STERLING RANCH FILING 2-MARKSHEFFEL ROAD BETWEEN VOLLMER ROAD - STERLING RANCH ROAD

STREET IMPROVEMENT PLANS

FEBRUARY 2018

"ULTIMATE" MARKSHEFFEL ROAD (MODIFIED) 4 LANE URBAN PRINCIPAL ARTERIAL CROSS SECTION
SCALE: NTS

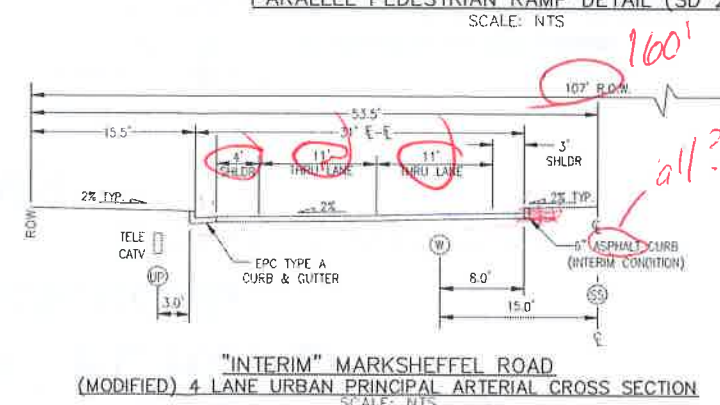
Revise to County standards

This doesn't match the Preliminary Plan SP-14-015

Revise to half of County standard cross-section.

"INTERIM" MARKSHEFFEL ROAD

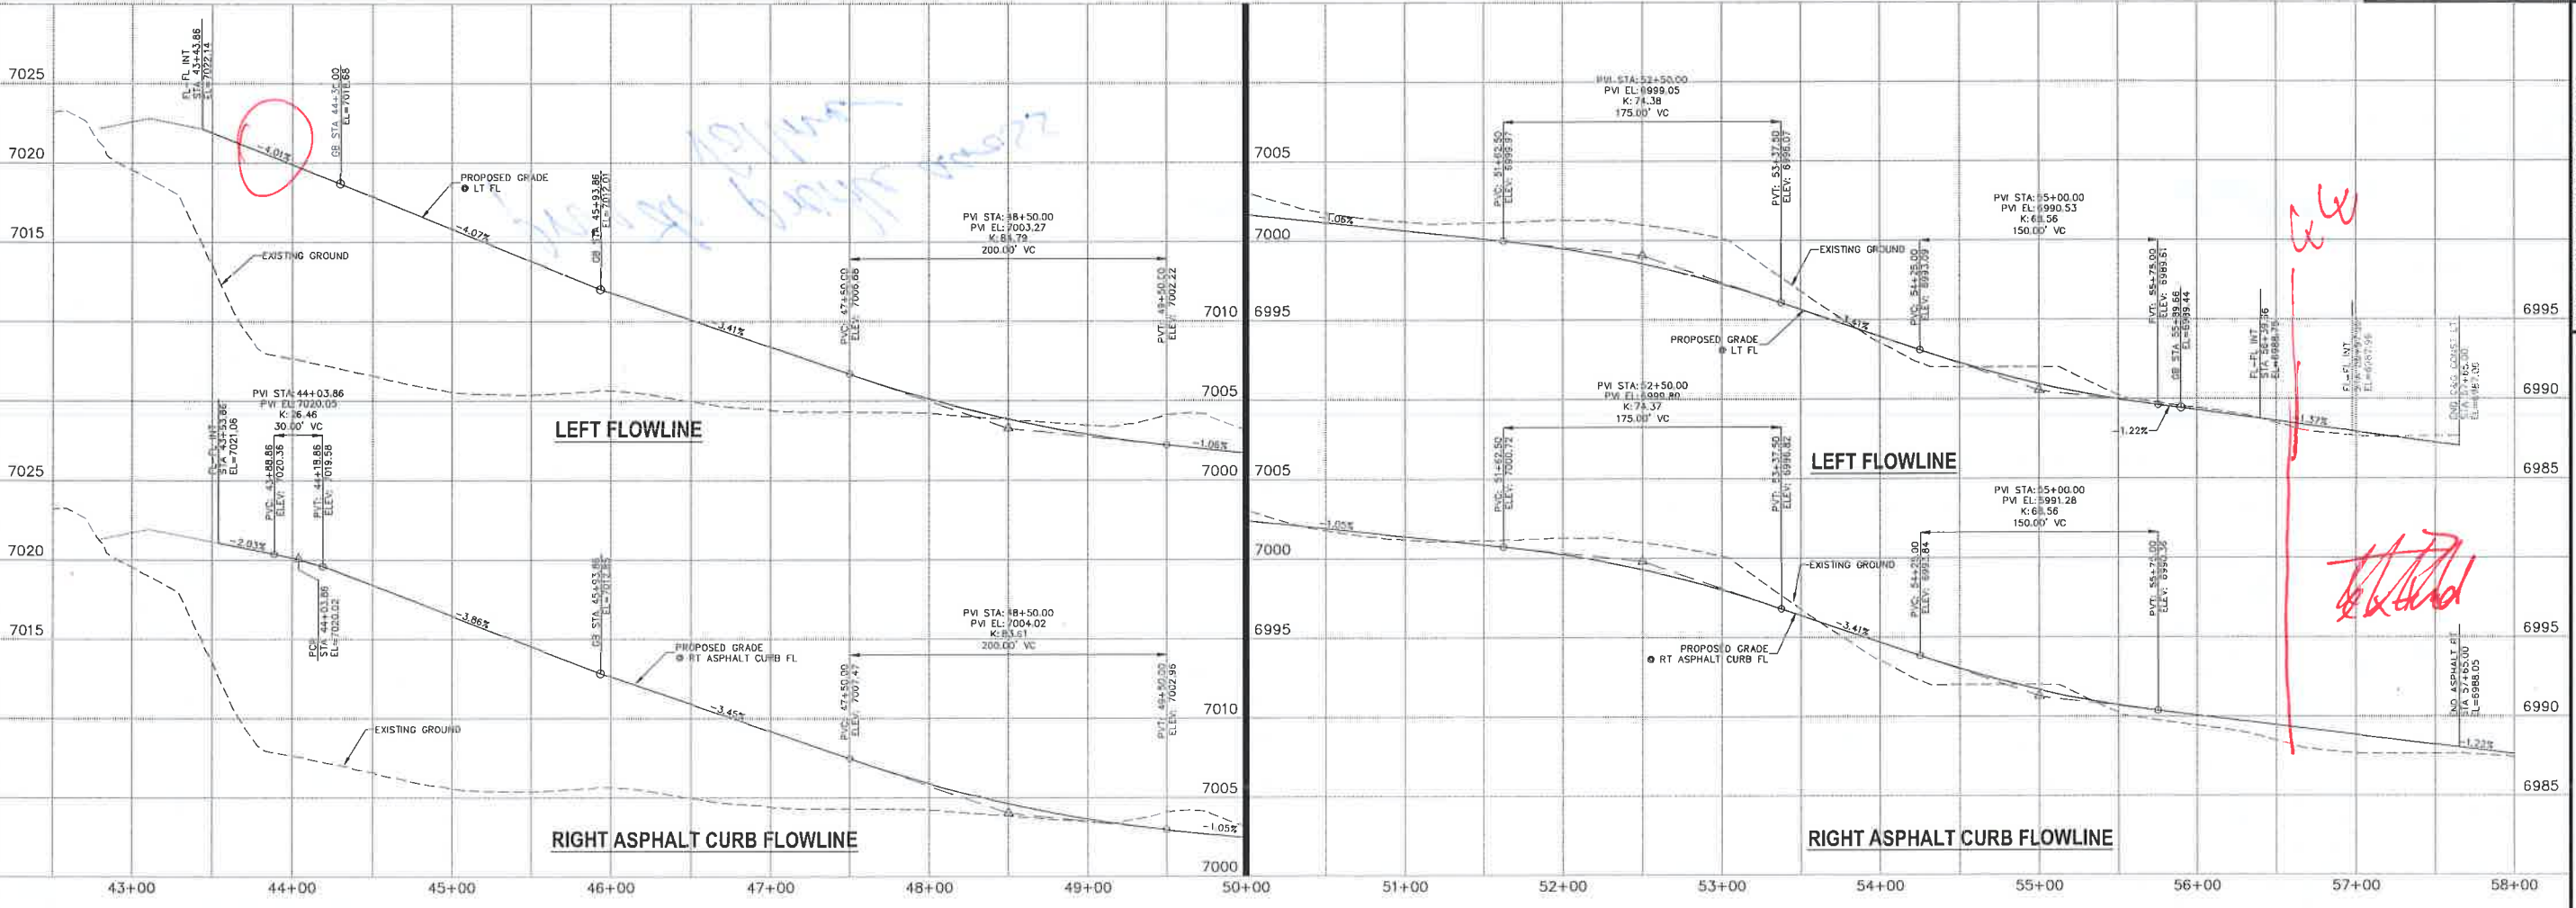
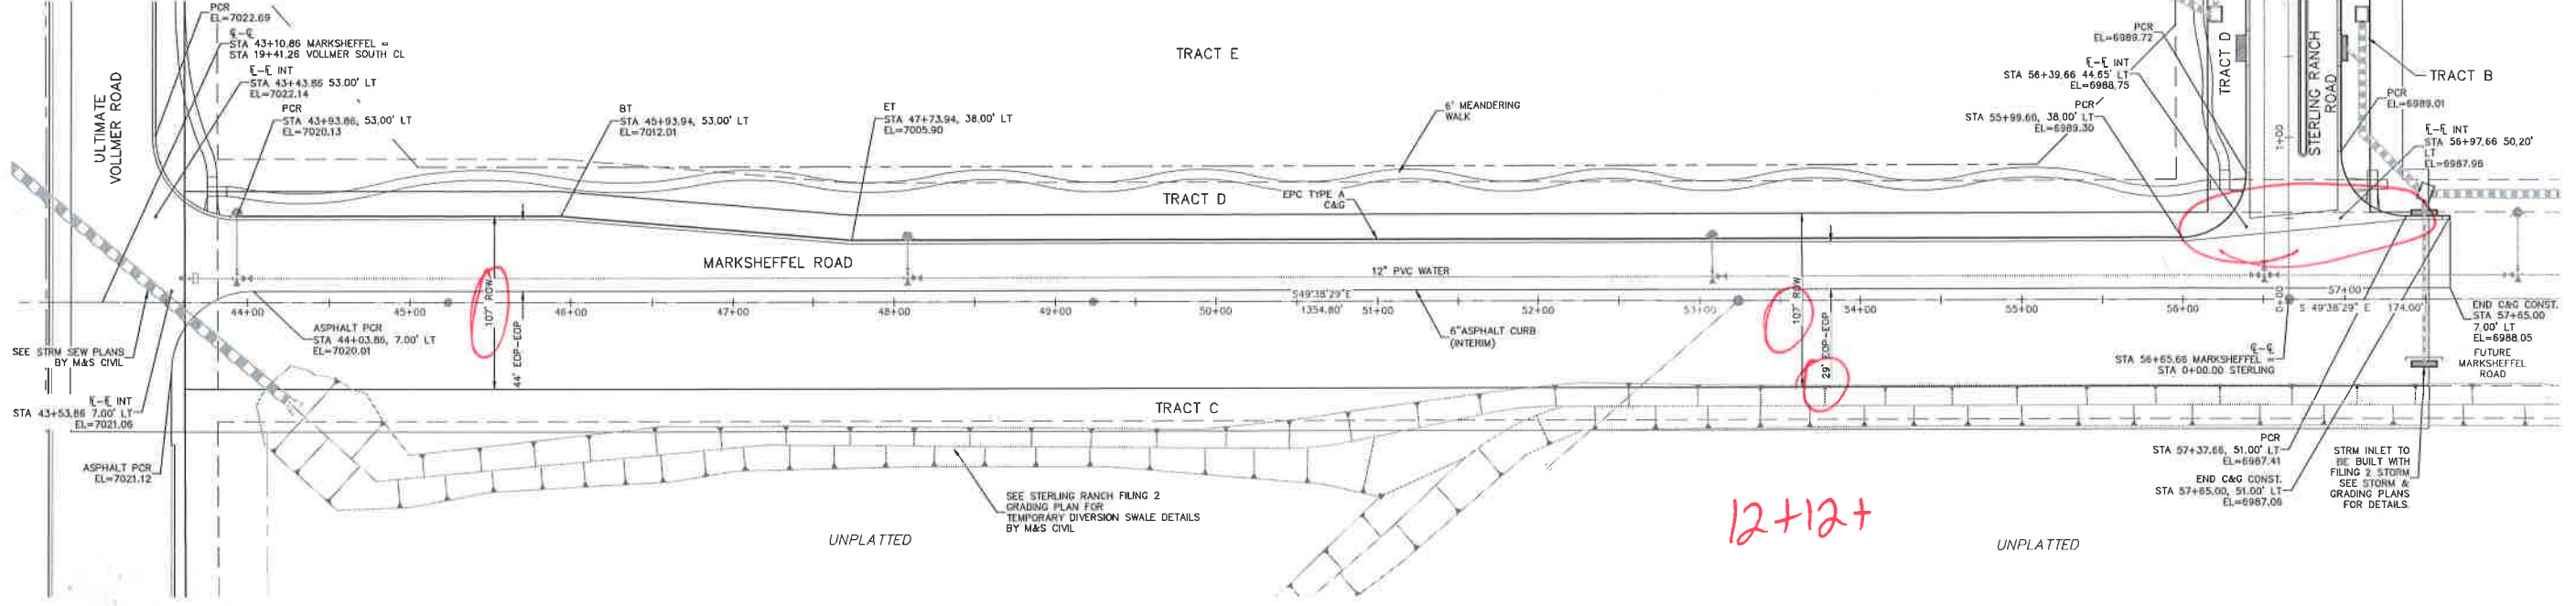
Identifier arrow does not extend to ROW edge. Additionally Marksheffel Road ROW is 160 feet. Please show.

SEE STERLING RANCH FILING 2 GRADING PLAN FOR TEMPORARY DIVERSION SWALE DETAILS BY M&S CIVIL. See comment on drainage report. Show the proposed RCP construction.

Call out Inlet sizes on street plans and profiles.

Call out location of Sterling Ranch Road, on the profile.

(TEMPORARY)
 MARKSHEFFEL ROAD

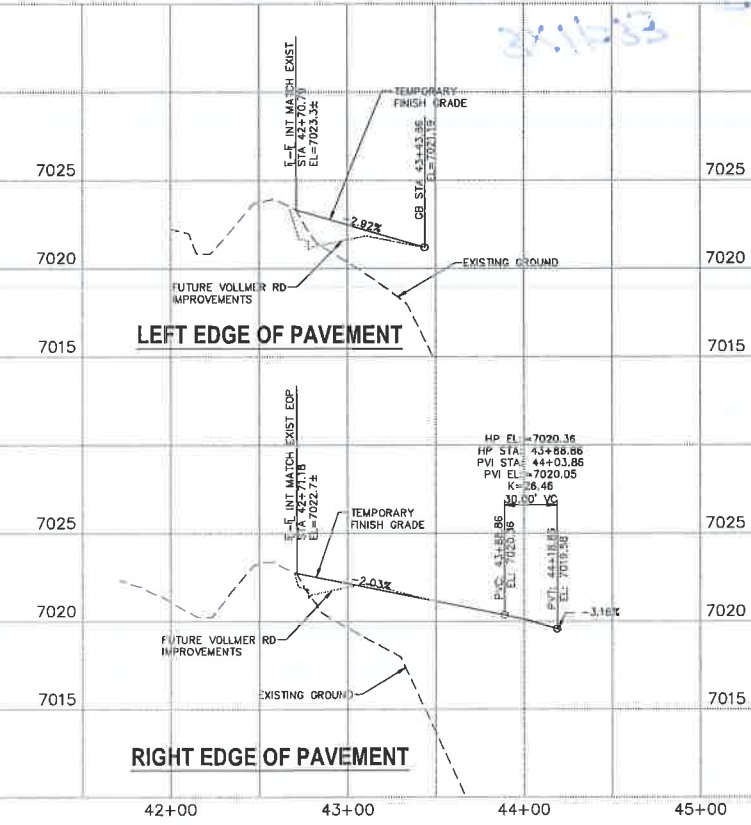
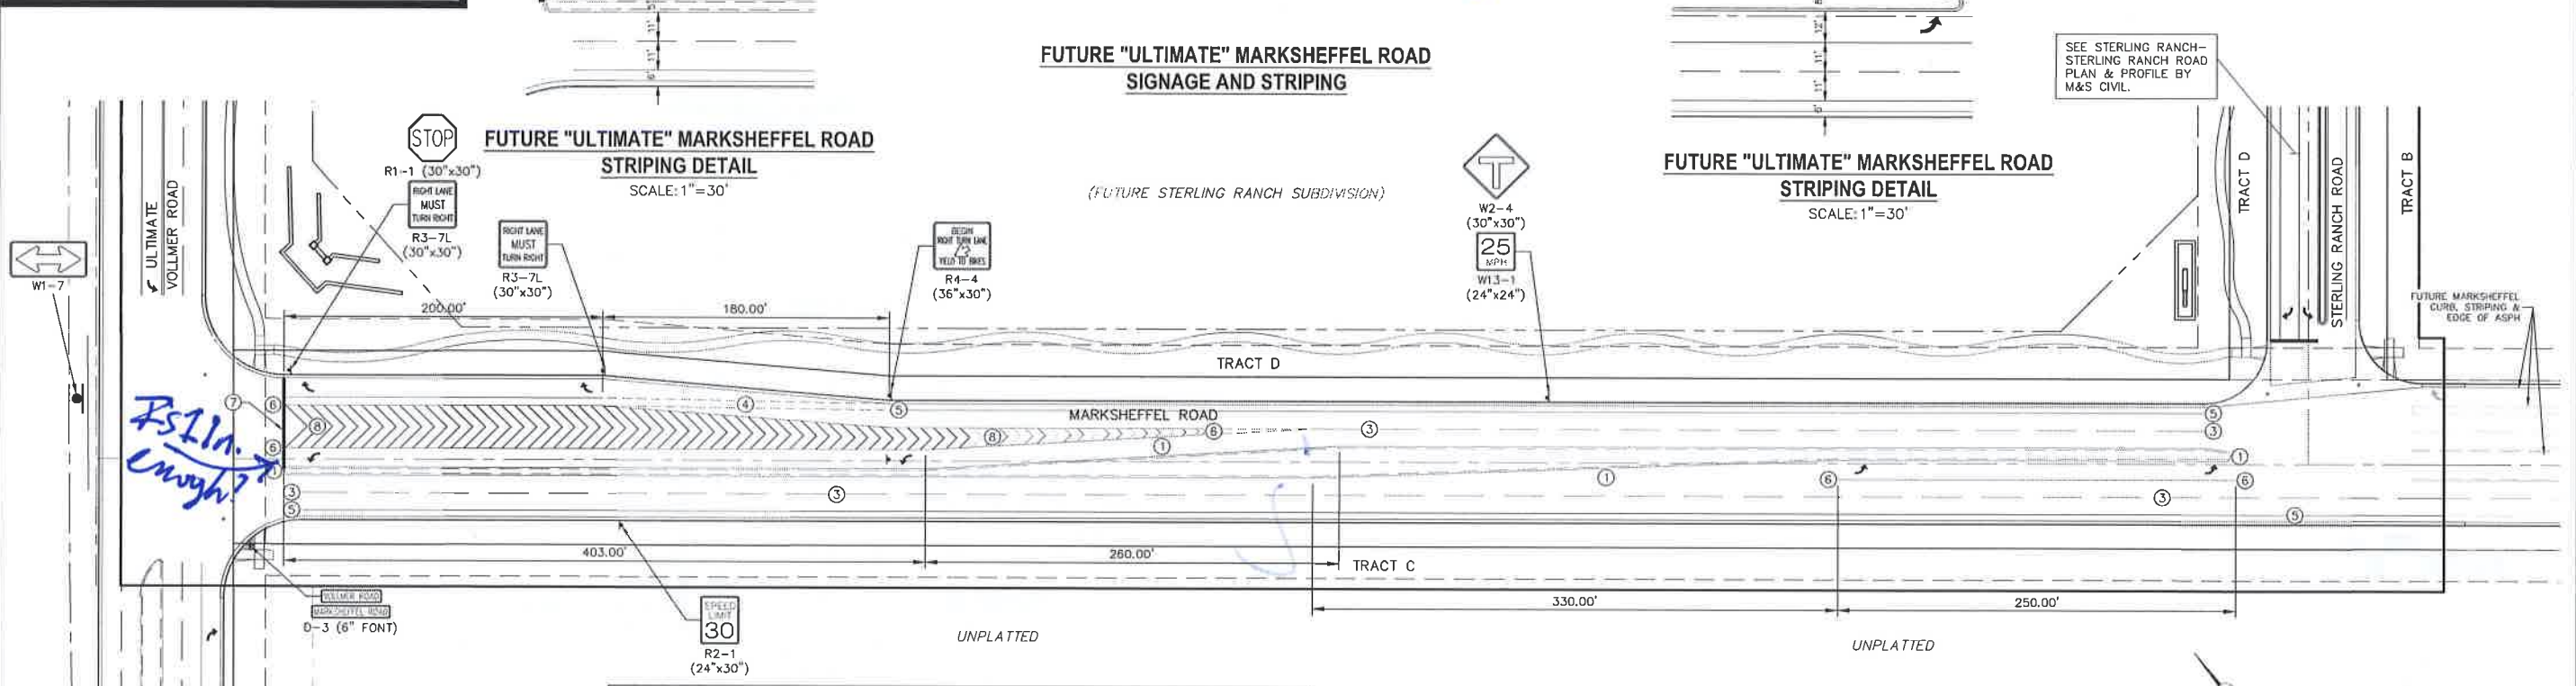
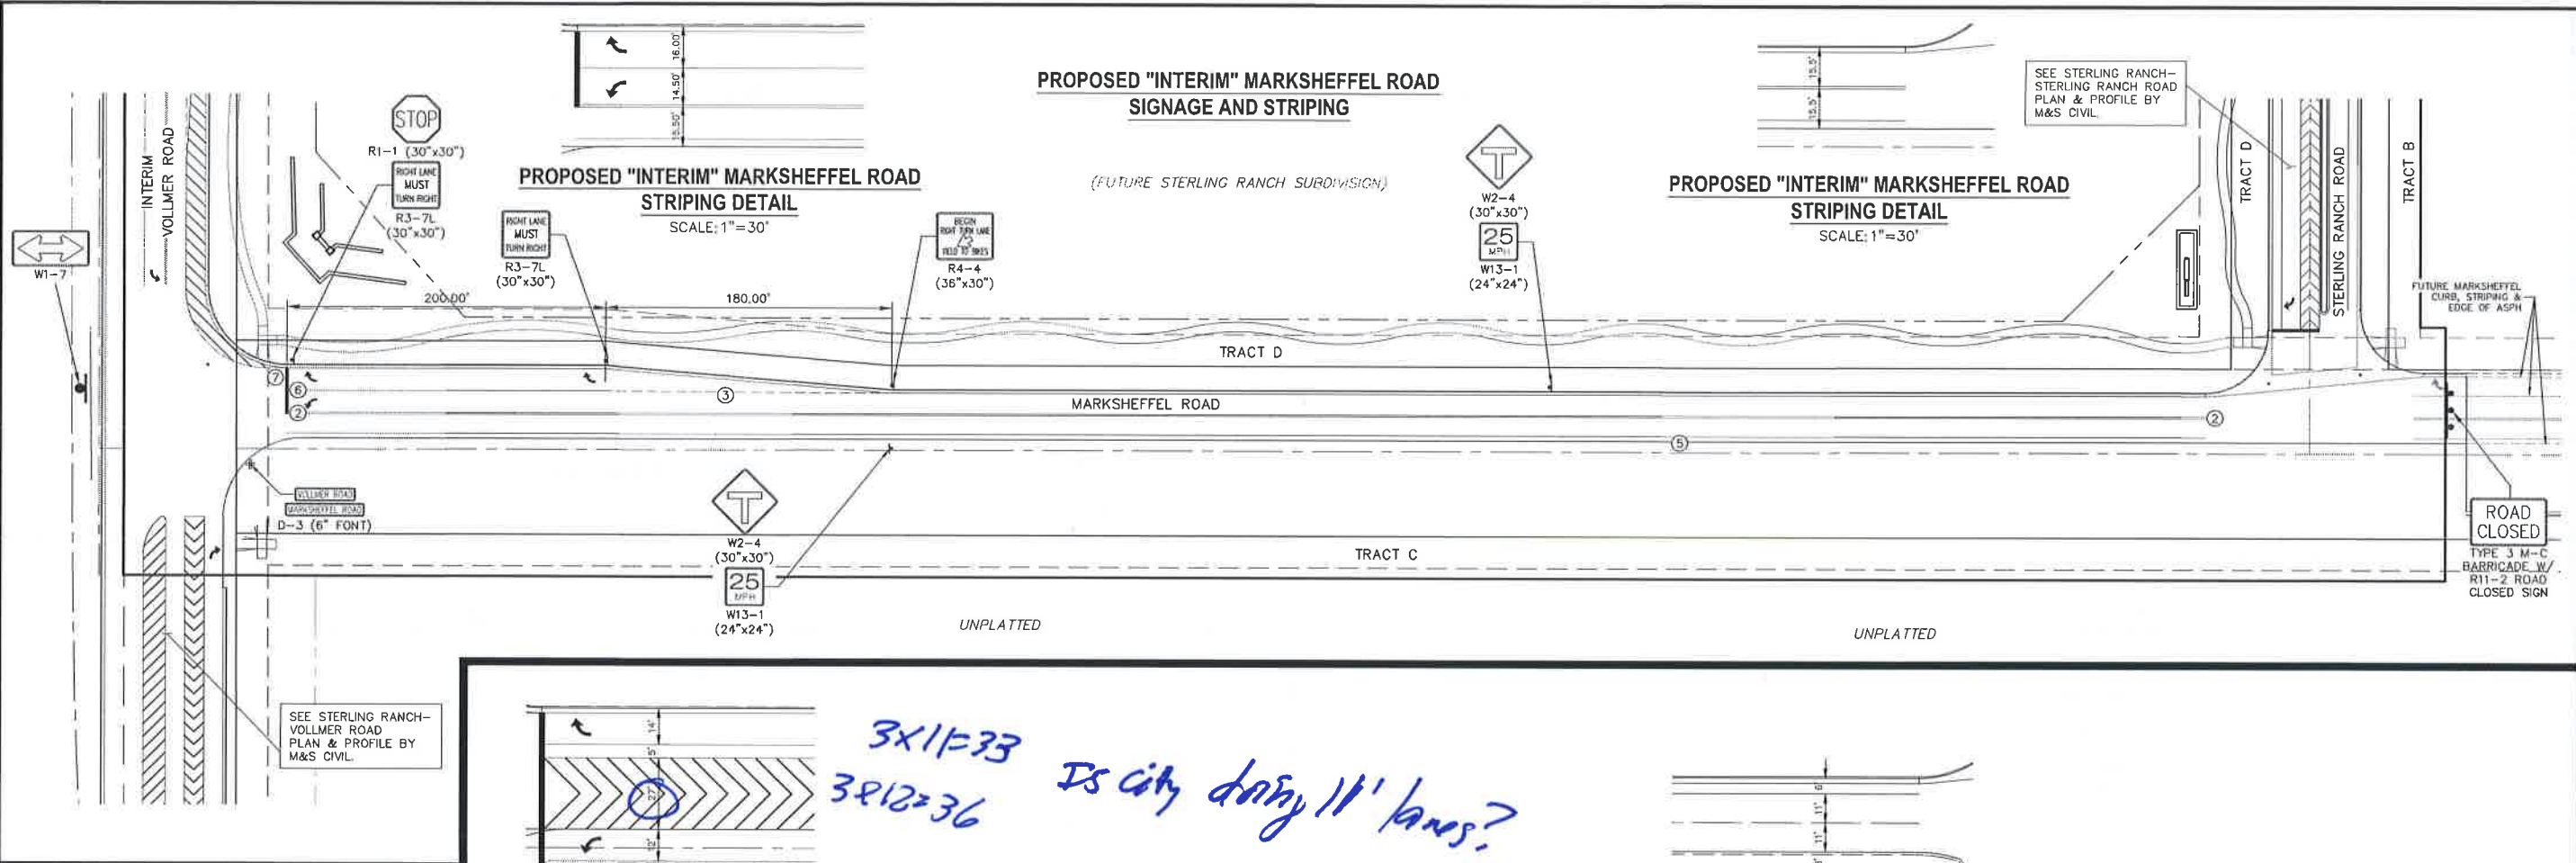
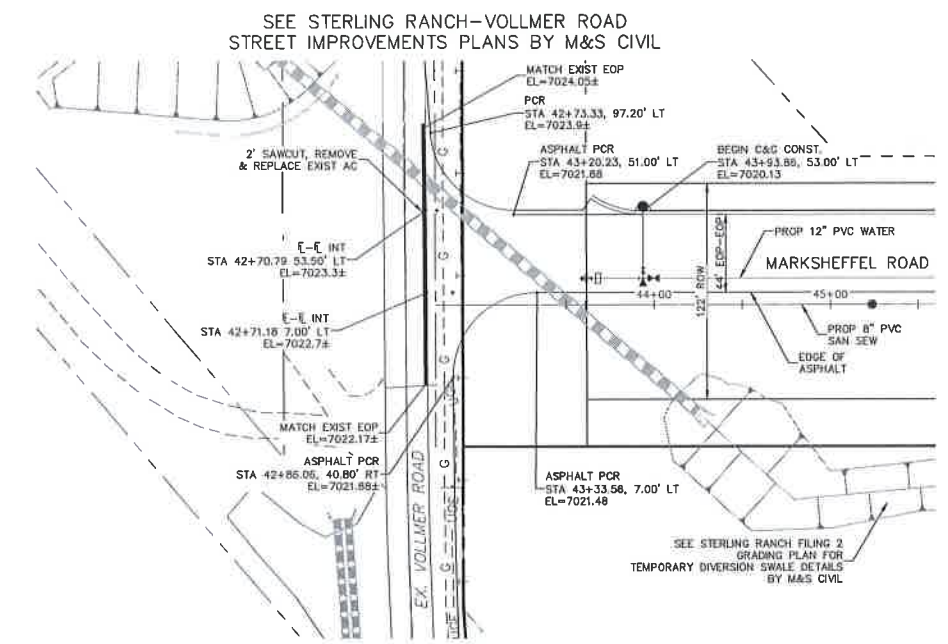
Provide a statement regarding what this design is for and allowable time frame for use before expansion. Provide a cross section. Provide a deviation request if this is to last past the time of preliminary acceptance. Building permits may be conditioned on the interim section being completed.
